**KIRKLEES METROPOLITAN COUNCIL
INVESTMENT & REGENERATION SERVICE**

Reference No: 2019/62/92519/W

Site Address: 3, Cobcroft Road, Fartown, Huddersfield, HD2 2RU

Description: Erection of single storey rear extension and two storey side extension (within a Conservation Area)

3 Rear Elevation
1 : 50

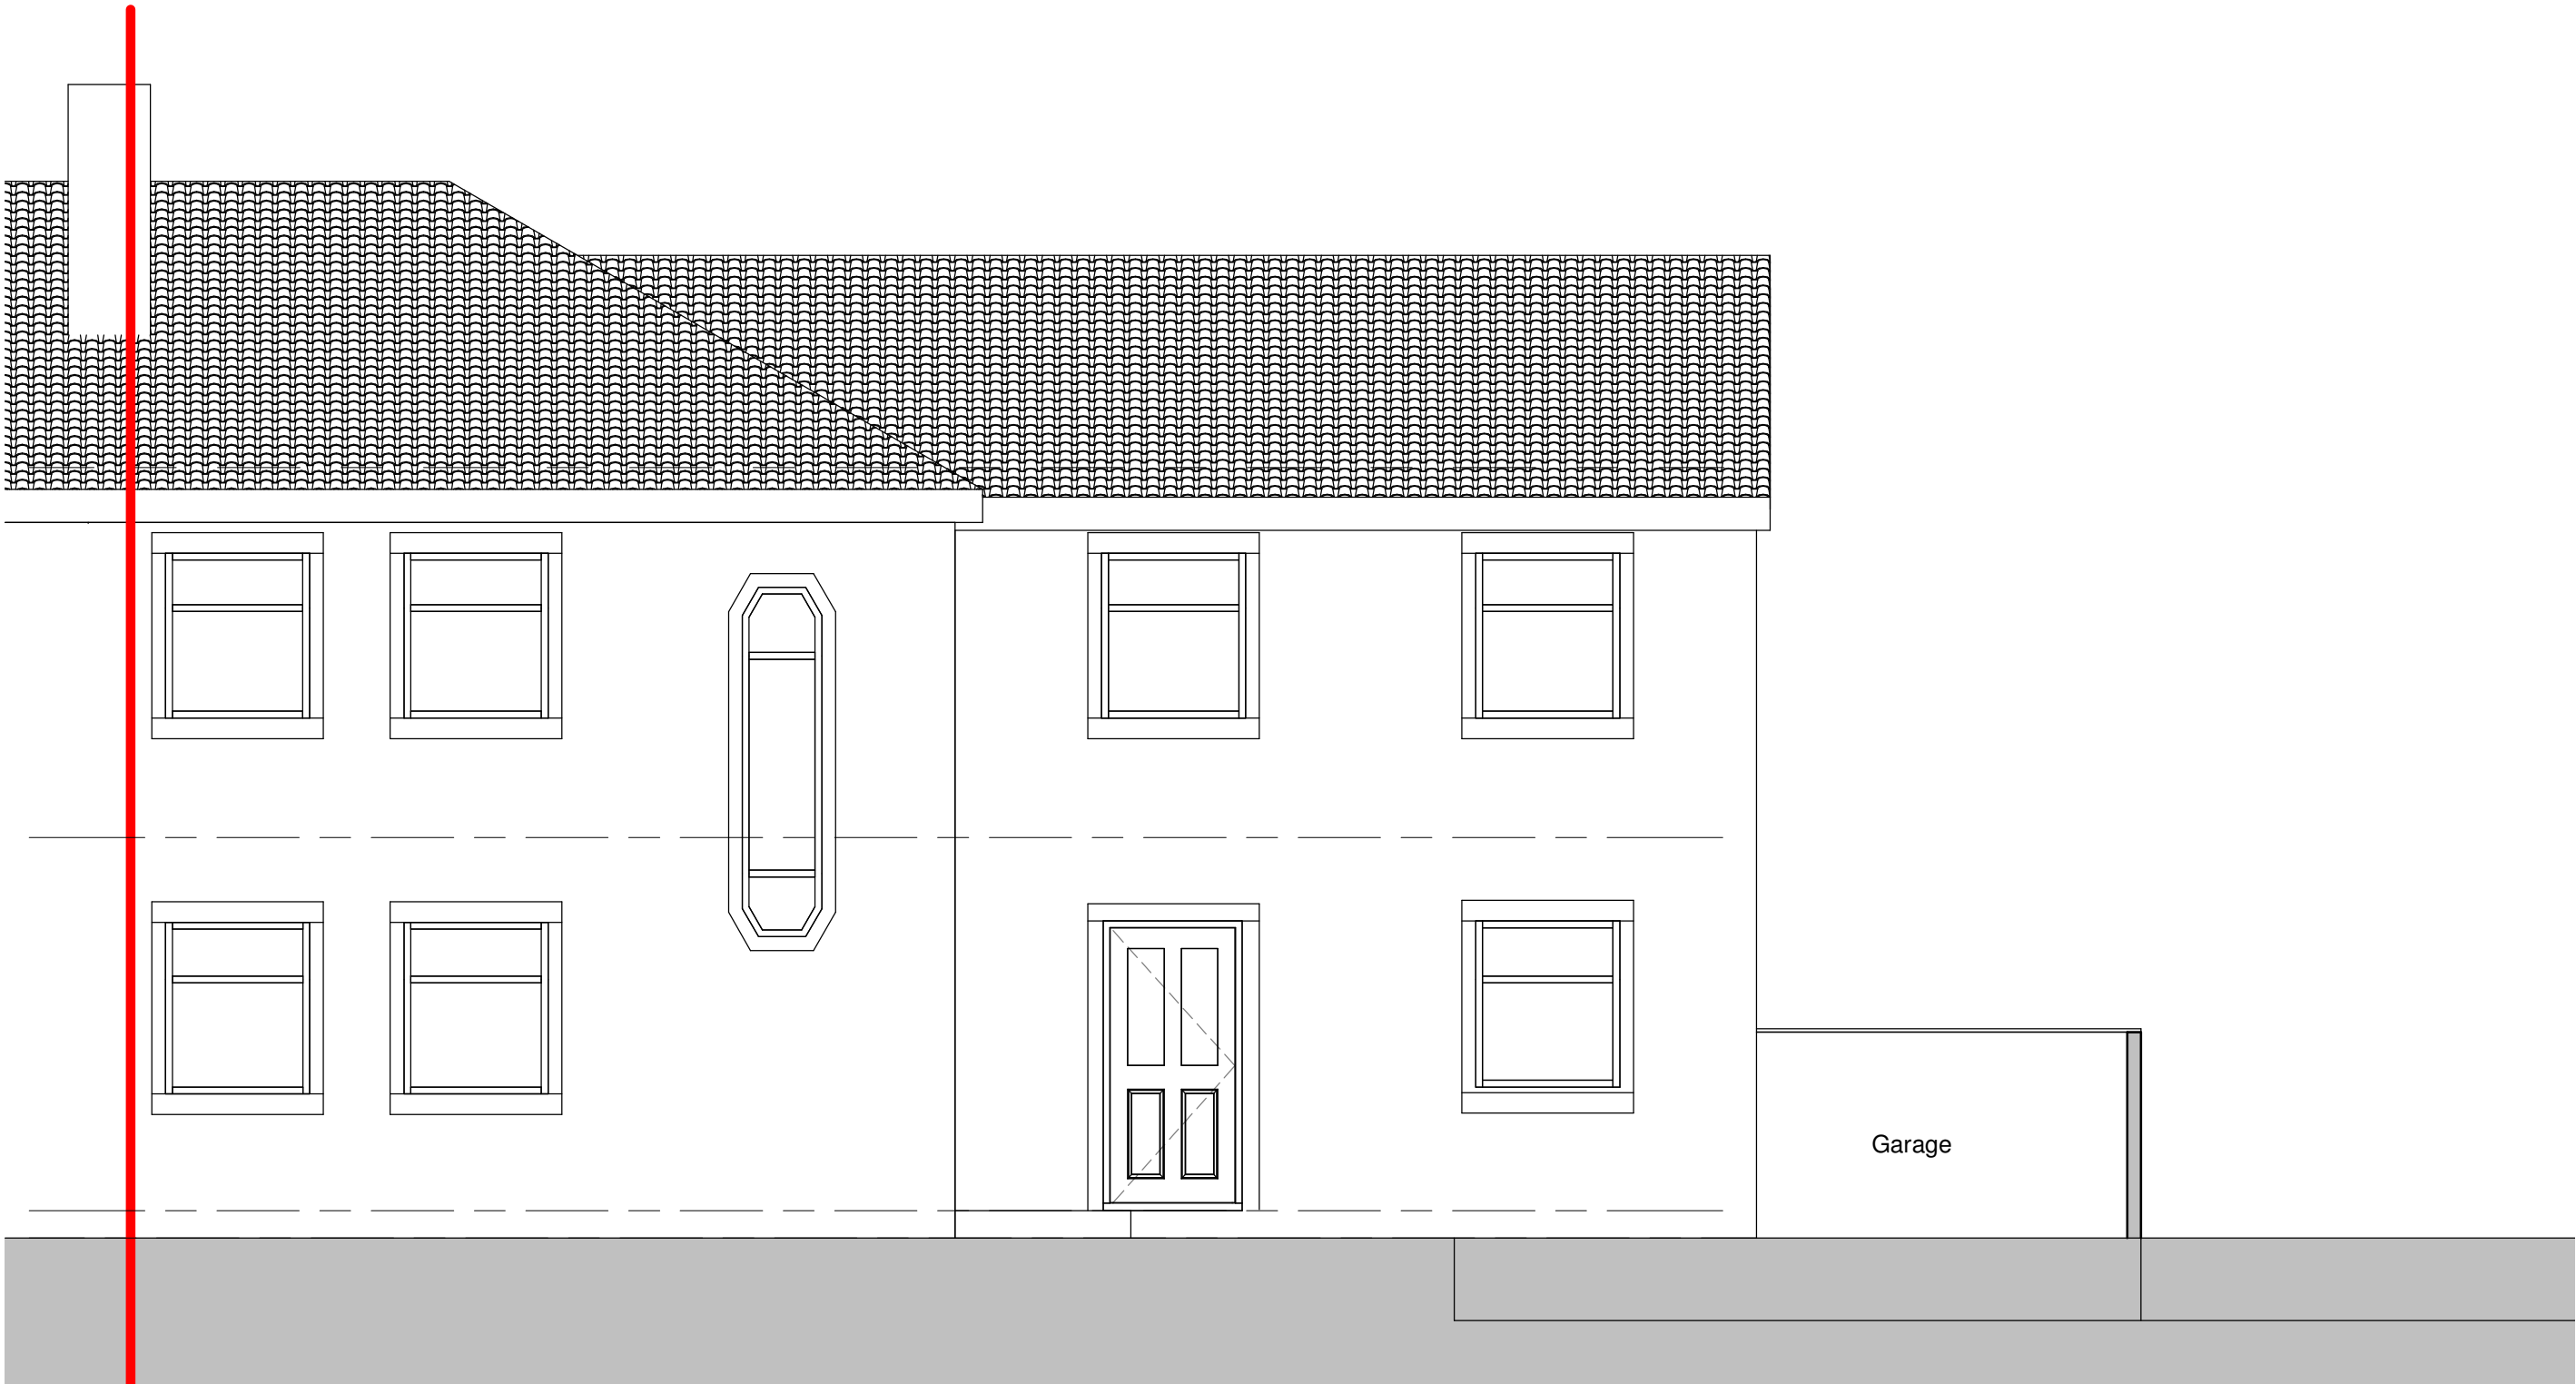
Given the position of the dwelling in relation to Cobcroft Road, it has been assessed that there would be some impact on the appearance of the street scene, as the side extension in particular, would be readily visible from public vantage points. As such KC Conservation and Design have been consulted, in which concerns were raised as the original plans were considered to have a significant impact on the character of the semi-detached properties and the wider street scene. More specifically the officer raised concerns, in regards to the fact that the extension would not follow through with the symmetrical design. Therefore, to overcome some of the harm, concerns were raised with the agent regarding the above and amended plans were received on the 30th September 2019.

After reviewing the amended plans, it has been considered that the design of the two storey side extension would have an acceptable impact on visual amenity, as it would follow on from the original property and harmonise well with this and other half of the semi-detached pair. The building materials would match those that exist on the host property and therefore would allow the extension to harmonise well with the existing. Nonetheless, a condition will be attached to the decision notice to ensure visual amenity is protected.

The additional fenestration within the front and rear elevations are also considered satisfactory as they will be in keeping with those that exist on the host property. For these reasons, it has been noted that the initial concerns raised by the Conservation and Design officer have been overcome.

In regards to overlooking, the submitted plans show two additional openings to be inserted into the rear elevation of the two storey extension. These will be obscurely glazed and therefore, any harm on overlooking would be minimal. Nonetheless, a condition will be attached to the decision notice stating that these openings will be fitted to a minimum of grade 4.

2 and 4 Cobcroft Road are the neighbouring properties adjacent to the front elevation of the host property. It has been assessed that there would be some harm on these neighbours amenity however, the submitted plans show the side extension to sit flush with the front elevation and therefore any harm on overbearing and overshadowing would be minimal.

Alongside this, it has been noted that additional openings will be inserted into the front elevation of the side extension. These appear to serve bedroom 1 and 5 and therefore there will be some impact on overlooking. However, it has been considered that any harm would not be over and above the existing situation.

The officer entered into discussions with the agent regarding the design of the two storey side extension and therefore amended plans were received on the 30th September 2019. The officer also entered into discussions with the agent regarding an updated site plan which was received on 4th October 2019.

KC Conservation and Design (informally): Concerns raised regarding the two storey extension having a symmetrical design. Amended plans submitted have overcome their concerns.
